DECISION DELEGATED TO HEAD OF PLANNING

Application No: H23-0907-22 **Applicant:** Taas Ltd

Proposal: Details of external gas and electricity boxes, existing and proposed site levels and floor levels, foul and surface water disposal and ground gas protection measures (Conditions 3, 5, 6 & 8 of H23-0897-20)

Location: Rear Of 260 High Road Whaplode Spalding

Orig Title
BUILDING REGULATIONS
Proposed Site Plan

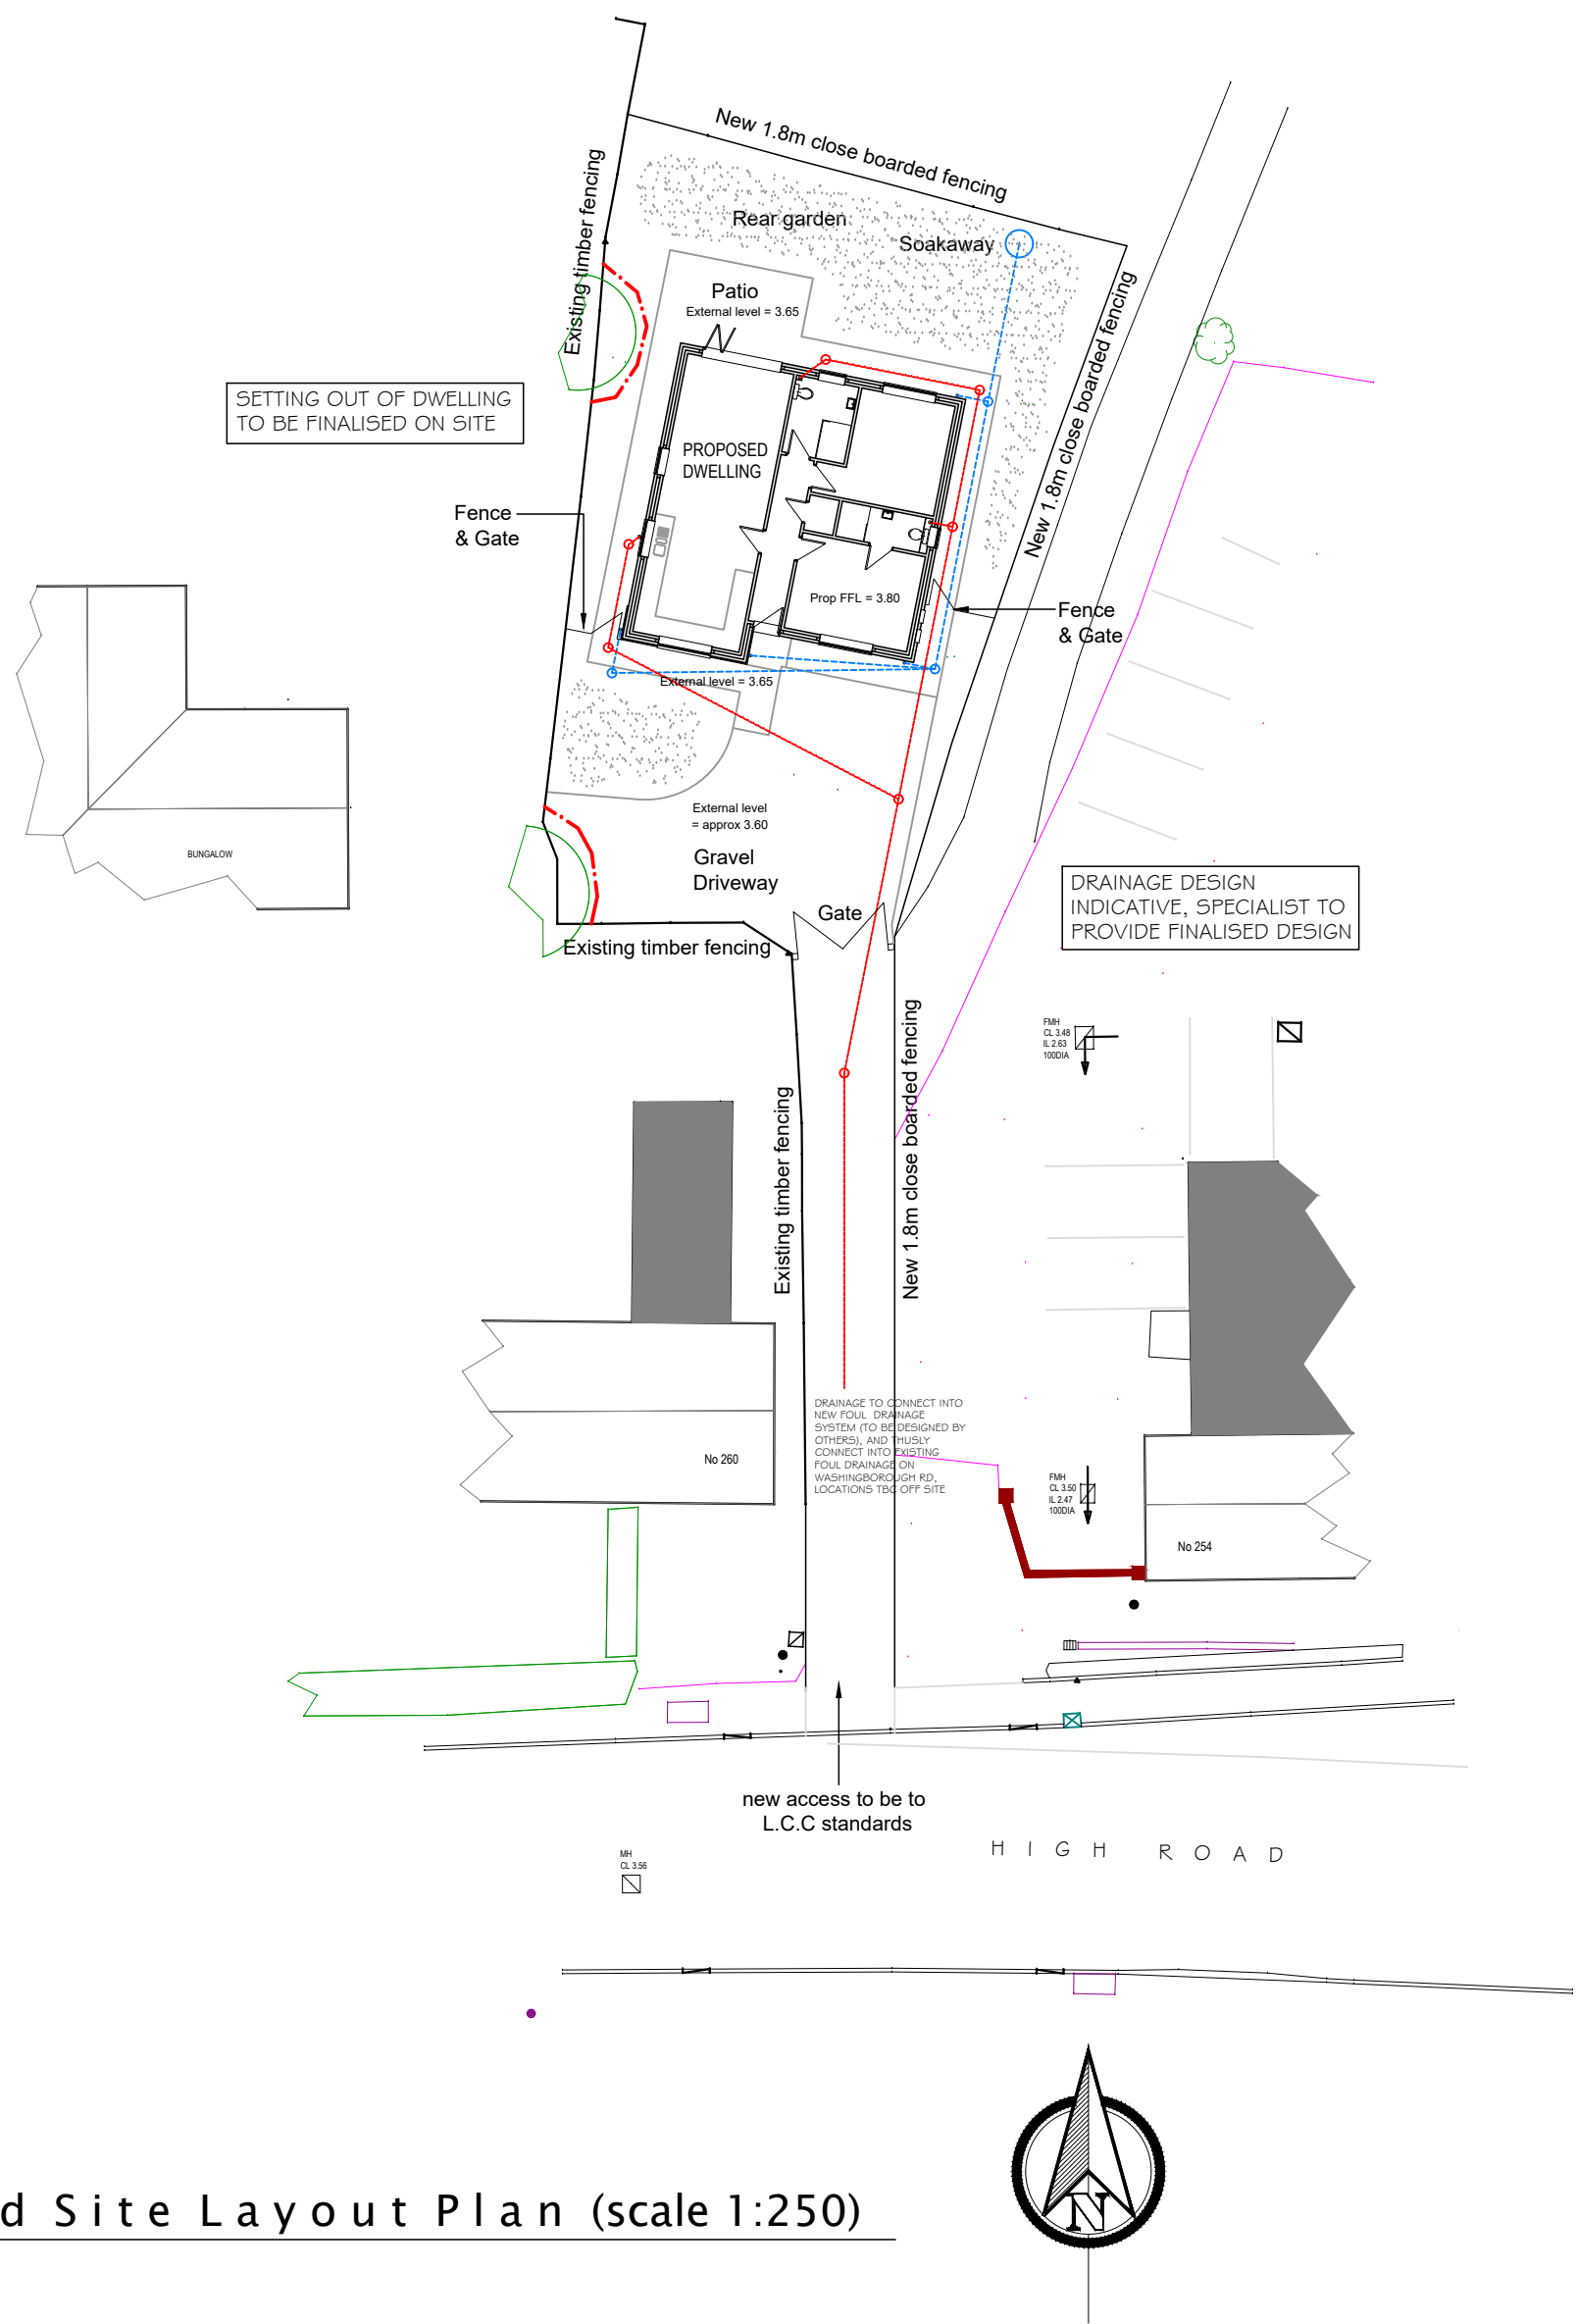
"The applicant has indicated that they intend to dispose of surface water via infiltration and I note they have provided soakaway sizing calculations in support of their application. However, I cannot see evidence that the viability of this proposal has been proven through ground investigation and the infiltration rate is tested in accordance with BRE Digest 365 standards. The Board recommends that on site testing is undertaken to determine infiltration potential of the onsite material. Following the drainage hierarchy, if a strategy reliant on infiltration proves unviable, we would usually expect the applicant to propose a discharge to a watercourse. However, I acknowledge that this option may be unlikely, as I am not aware of any watercourses in the immediate vicinity of the site. Nonetheless, if the applicant proposes to discharge surface water to a watercourse, consent would be required under Byelaw 3. Please note that we recommend that any discharge is in line with the Non-Statutory technical standards for sustainable drainage systems (SuDS), therefore the Board is unlikely to grant consent for discharges in excess of greenfield rate."

Foul water is to connect to existing mains drainage, with surface water to be addressed via a soakaway located to the northern rear of the dwelling.

"In light of further conversations with the applicant, I am pleased to see that initial testing shows that a drainage strategy reliant on infiltration is likely to be achievable on the proposed development, as evidenced within Soakaway Calculations - Amendment 1. If for any reason a strategy wholly reliant on infiltration does not prove viable and a surface water discharge is proposed to a watercourse, consent would be required under Byelaw 3. Please note that we recommend that any discharge is in line with the Non-Statutory technical standards for sustainable drainage systems (SuDS), therefore the Board is unlikely to grant consent for discharges in excess of greenfield rate. However, I acknowledge that this option may be unlikely, as I am not aware of any watercourses in the immediate vicinity of the site, although this should be confirmed by the applicant."

Condition 6 of H23-0897-20 has now been addressed.
